Arun District Conservation Area Advisory Panel
c/o Civic Centre

22nd February 2021

Application No: AB/7/21/L
Site Address: Vyne Cottage 33 Mount Pleasant Arundel BN18 9BD
Description of works: Listed building consent for the replacement of 12 No. windows & 1 No door.

1. All dimensions in millimetres (mm) and levels in metres (m) unless noted otherwise.
2. This drawing to be read in conjunction with all other relevant drawings and specification.
3. All work to comply with the relevant British Standards, Codes of Practice and the Building Regulations.

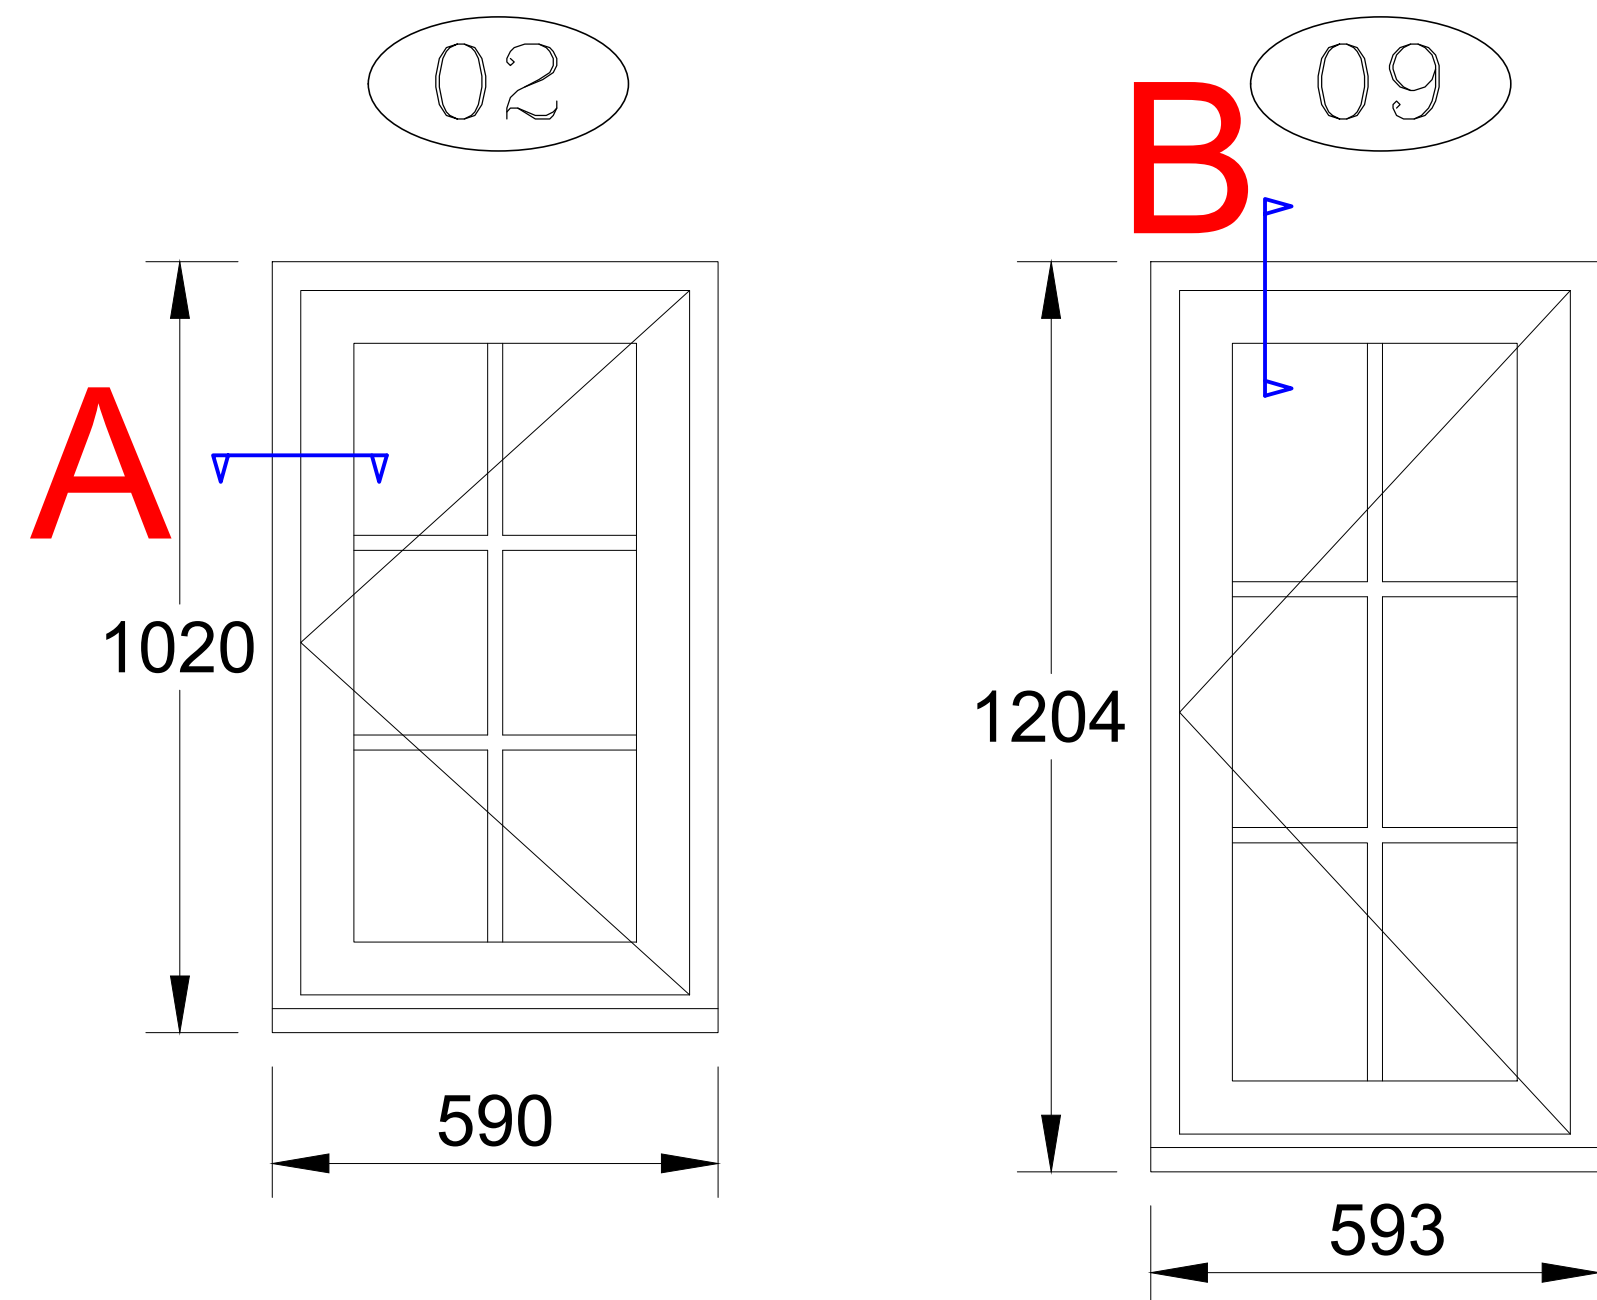
The proposal is to replace the existing windows with timber side hung casements but with standard double glazed units with what appears to be 'stick on' glazing bars.

There will be an unfortunate difference in appearance with the new windows particularly due to the increase in depth to the glazing units, the dead flat appearance to the glass and the use of thermal spacers. In terms of the effect on the character and appearance of the conservation area it is likely that the proposed works will sit in the lower end of less than substantial harm for the purposes of the NPPF.

If the Council considers that, in this instance, there is a case for replacement painted timber double glazed windows then it is strongly recommended that they should incorporate slim profile glazing units of approximately 12mm depth and with the use of properly formed glazing bars.
